**1250 AINSWORTH
LOT 3
POWERS POINTE FILING NO. 5**

DRAINAGE LETTER REPORT

PCD File No.
PPR-21-025

May 17, 2021
Project No. 20-290

1250 AINSWORTH ST.  
EL PASO COUNTY, CO  
EXISTING CONDITIONS DRAINAGE  
PLAN

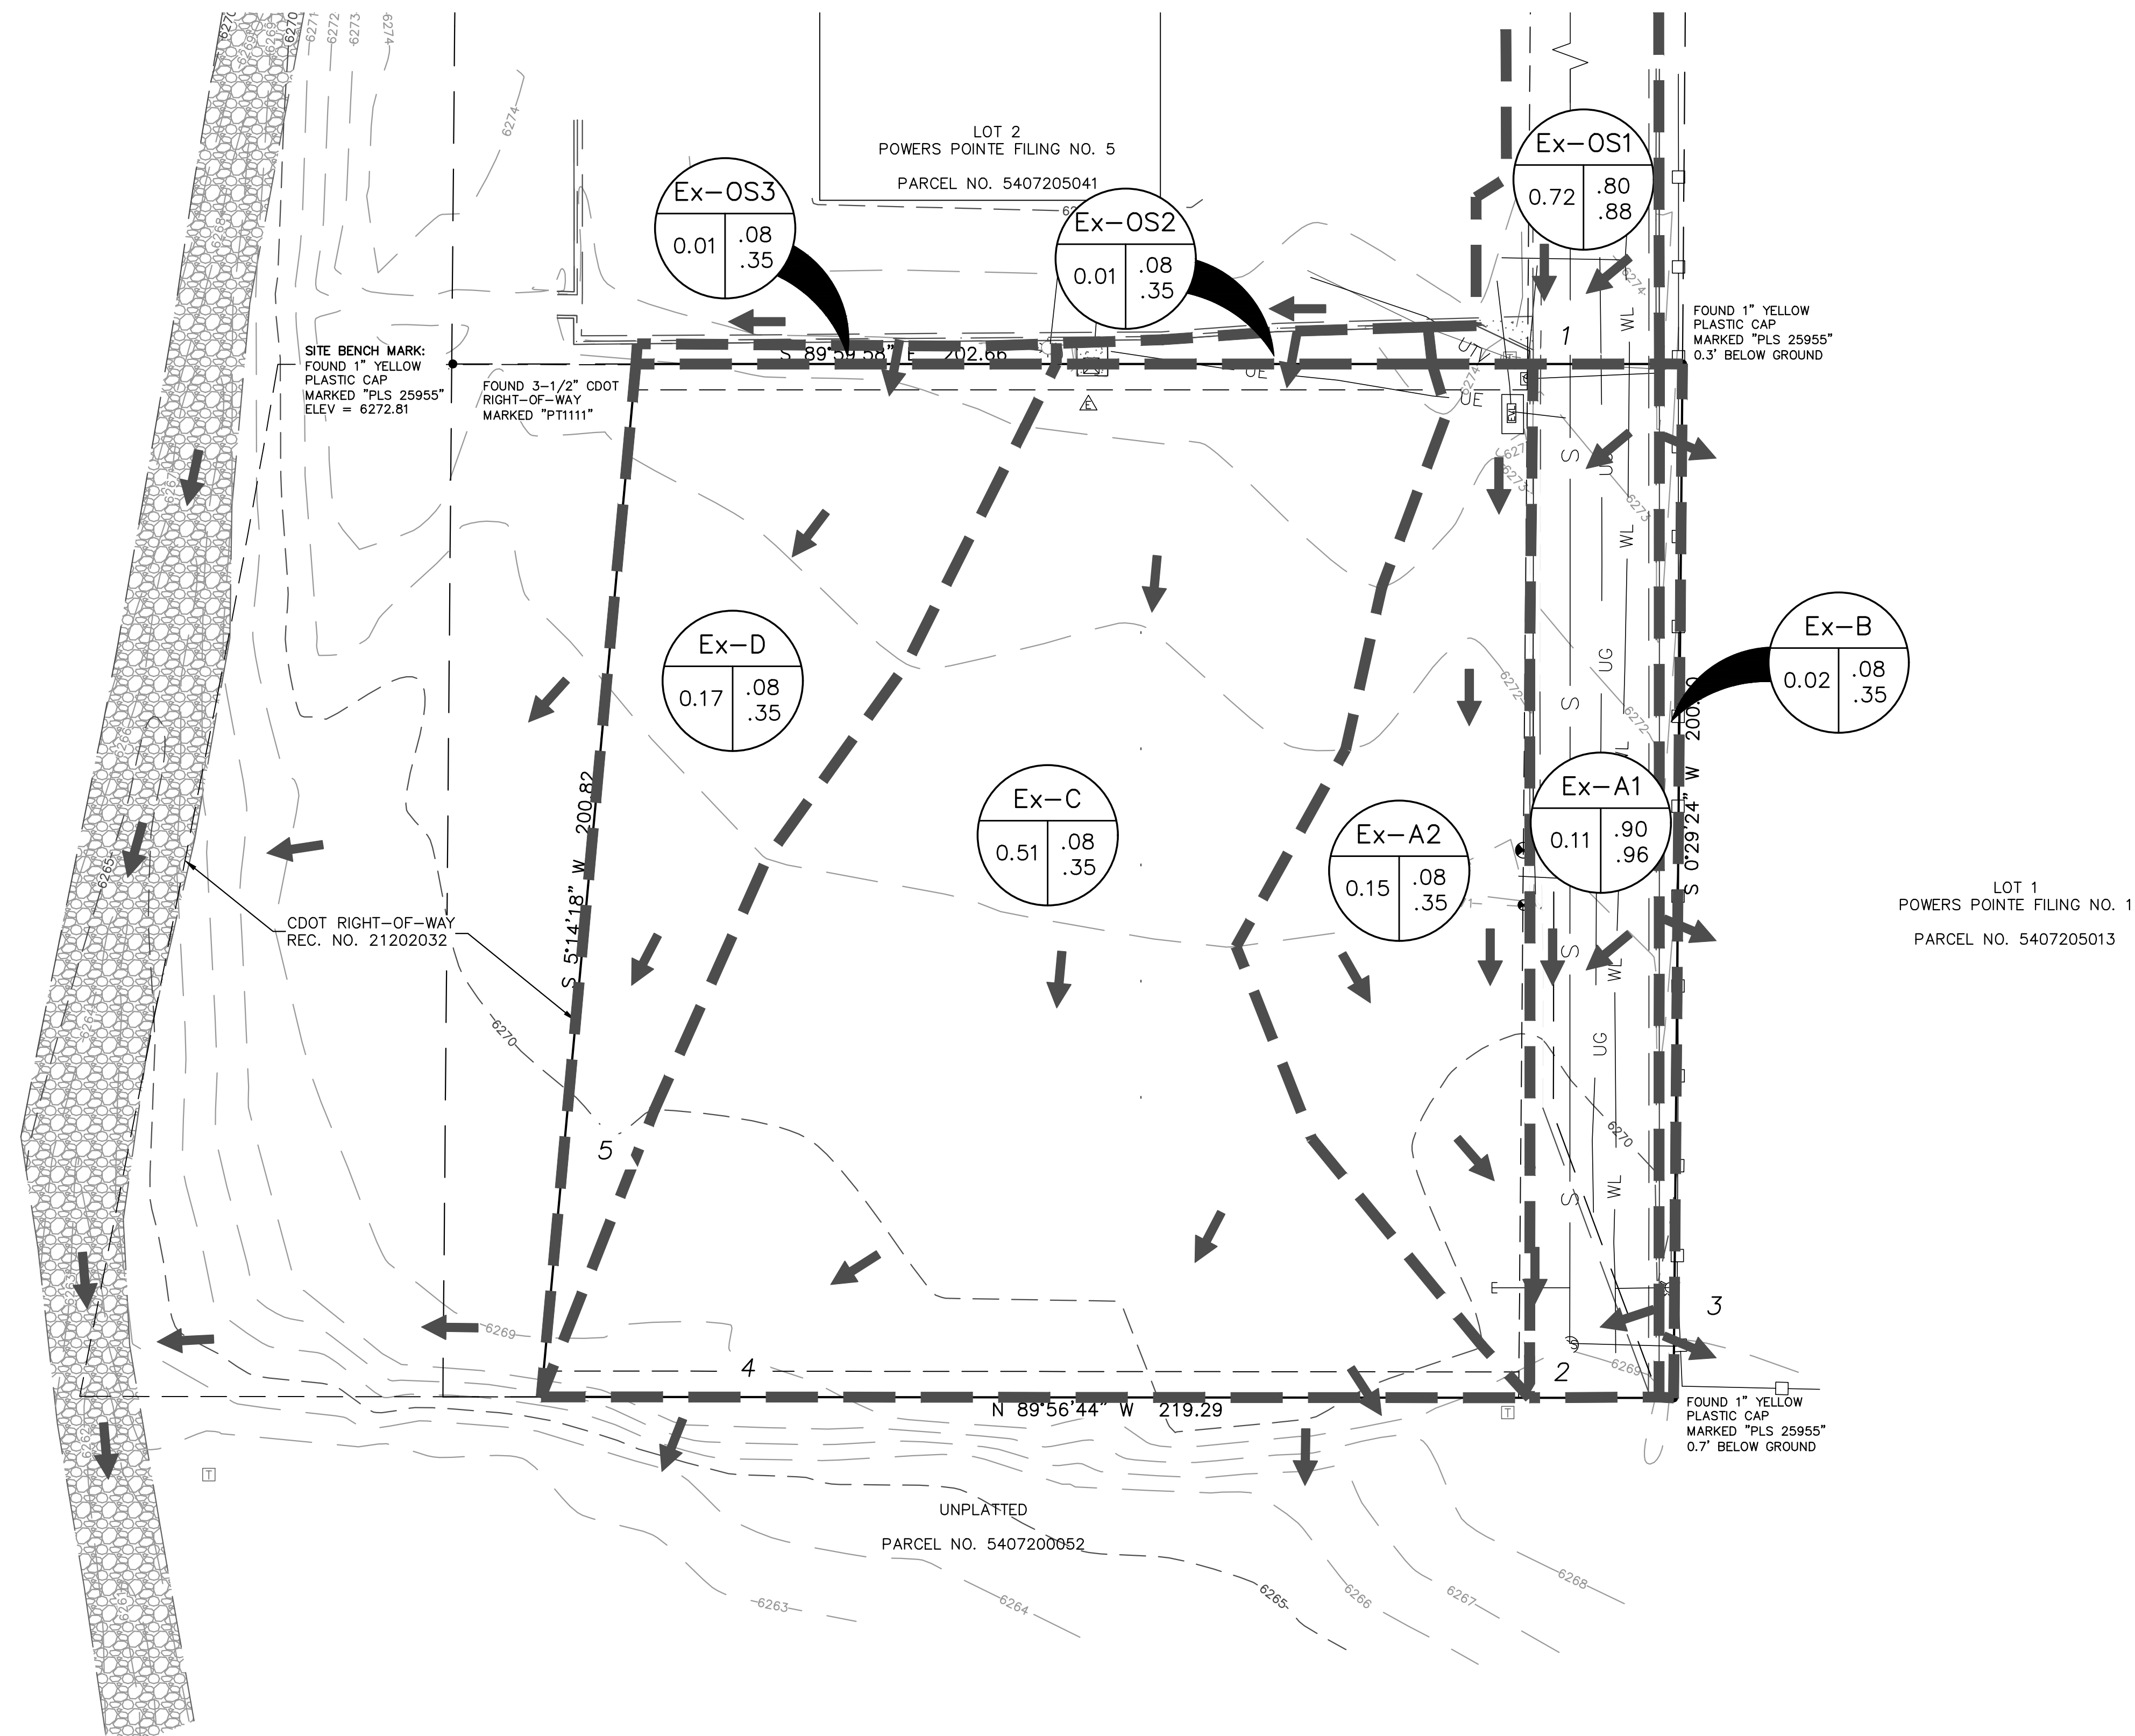
Per the existing conditions drainage map it appears that a portion of runoff travels to the adjacent lots to the south and to the east. Please address the different areas all of the runoff is traveling to.

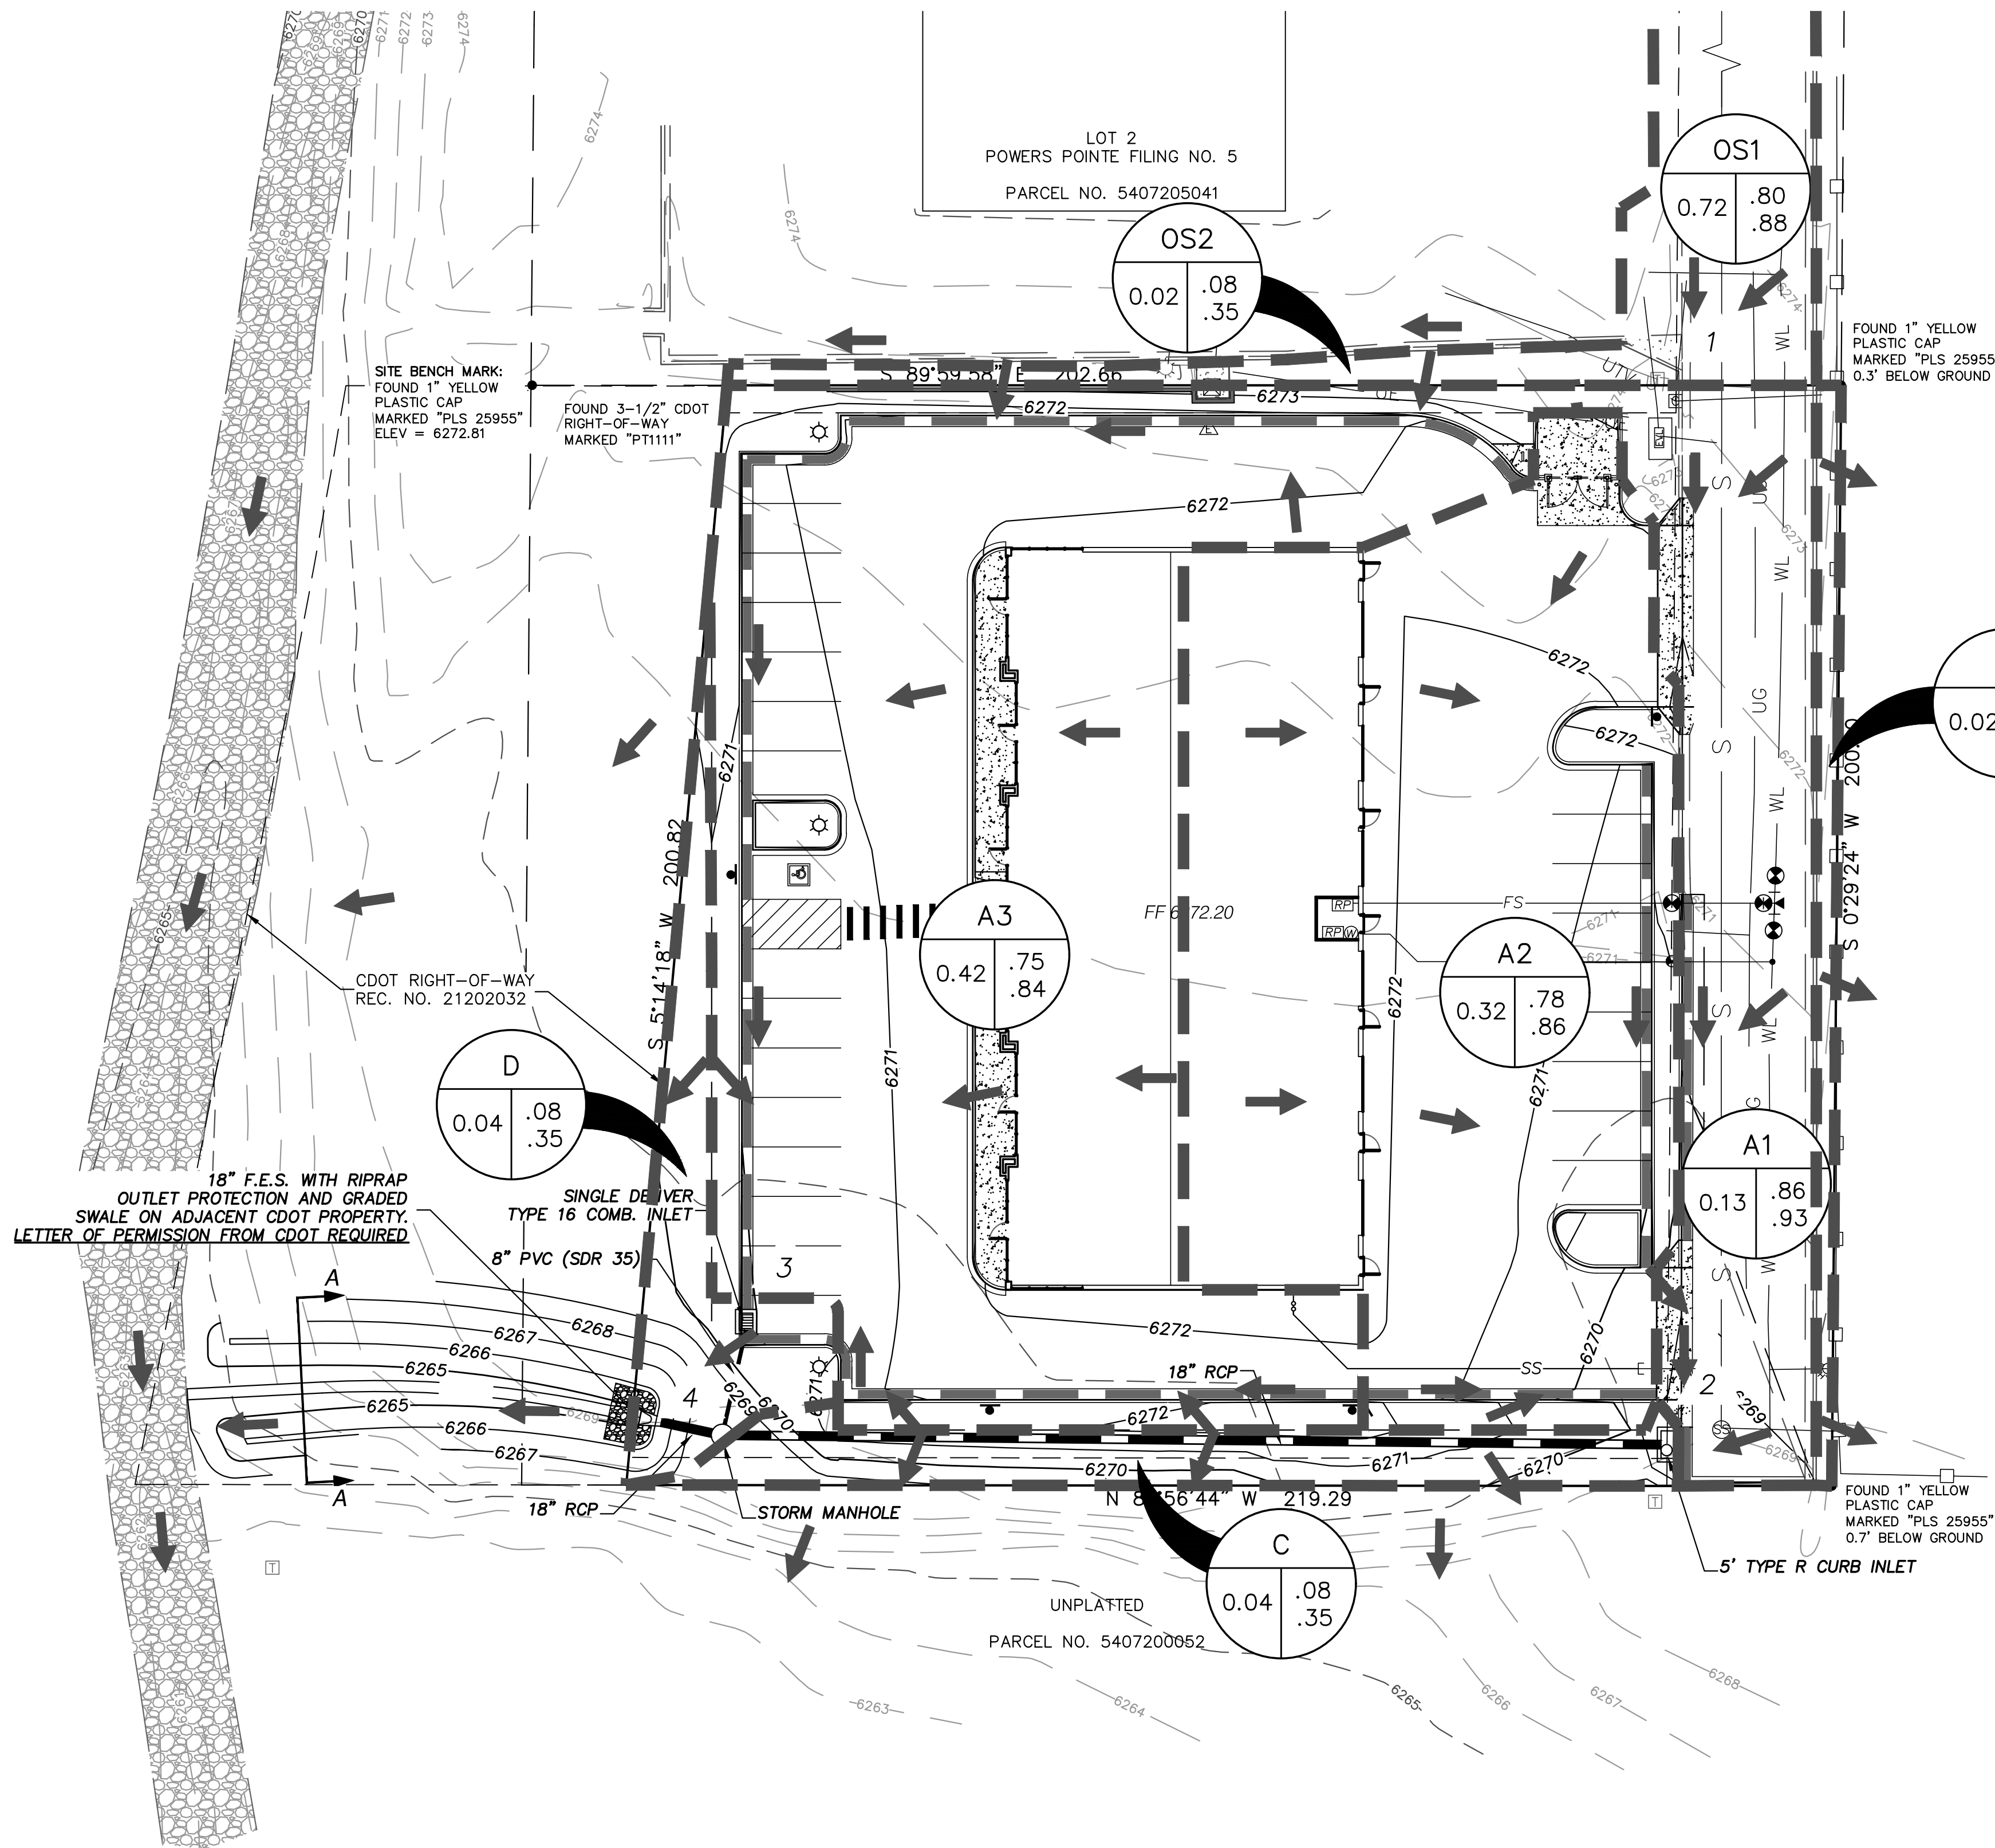
Developed drainage conditions map shows type 16 combination inlet. Revise to remove inconsistencies.
